Subject: Planning consultation - BN/65/22/PL Land at rear of Cedar End Eastergate Lane Eastergate PO20 3SJ

Having viewed the plans for the planning application no. BN/65/22/PL for the Sever land and erection of 1 No bungalow with new vehicular access (resubmission of BN/14/22/PL). This application is a Departure from the Development Plan and is in CIL Zone 3 and is CIL Liable as new dwelling, the nearest fire hydrant to this site is 270 metres away, 95 metres further than the 175 metres distance required for a domestic premises. If an alternative supply of water for firefighting is to be considered it will need to conform with the details identified in Approved Document – B (AD-B) Volume 1 2019 edition: B5 section 14. Otherwise the property will require domestic sprinkler or water mist system installed to BS9251 or BS8458 standard. This will either extinguish a fire or suppress it long enough for the Fire Service to prepare the additional equipment require to reach the property.

Land r/o Cedar End, Eastergate ^ Fire Authority Compliance ^ 1:500@A3 ^ 1671-SYM-00-ZZ-DR-A-0213 P01

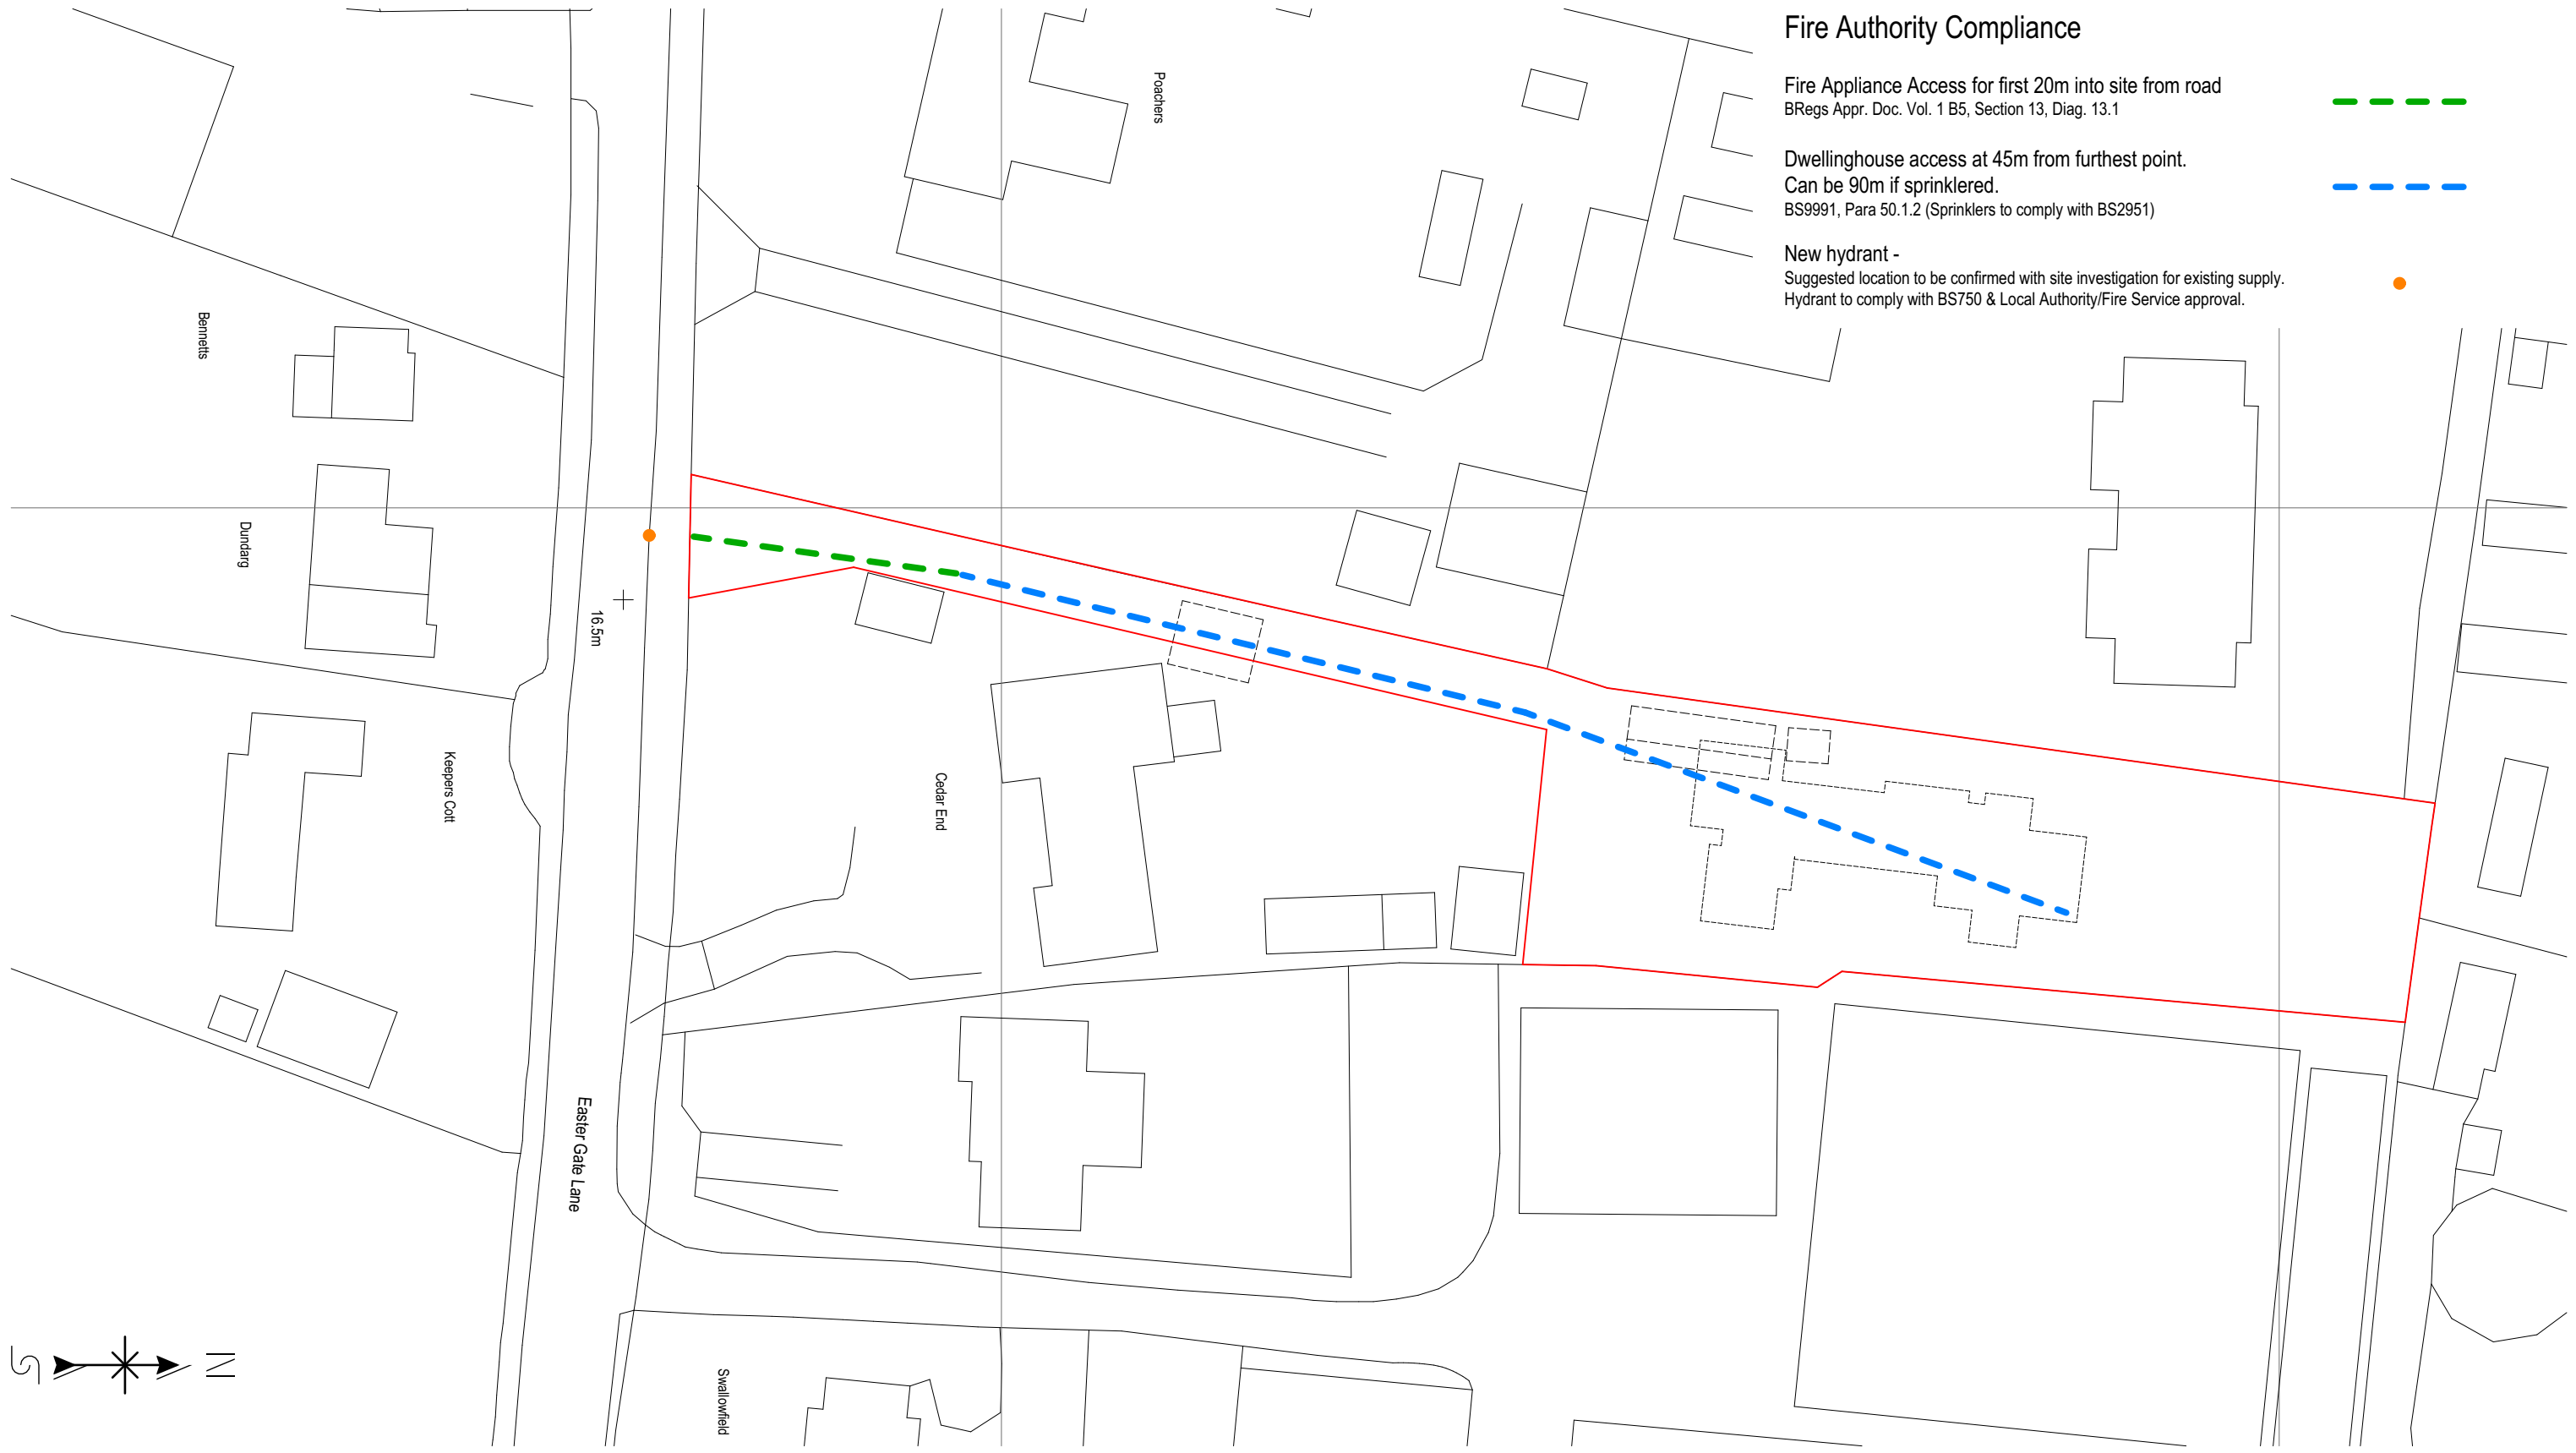
Evidence will also be required to show the access route has a suitable width and turning facility to enable a fire appliance to gain access to within 45 metres of all parts inside the dwelling and capable of turning and make their exit, in accordance with AD-B Volume 2 B5 section 15. Without these requirements a fire appliance may not be capable of attending the site in an emergency.
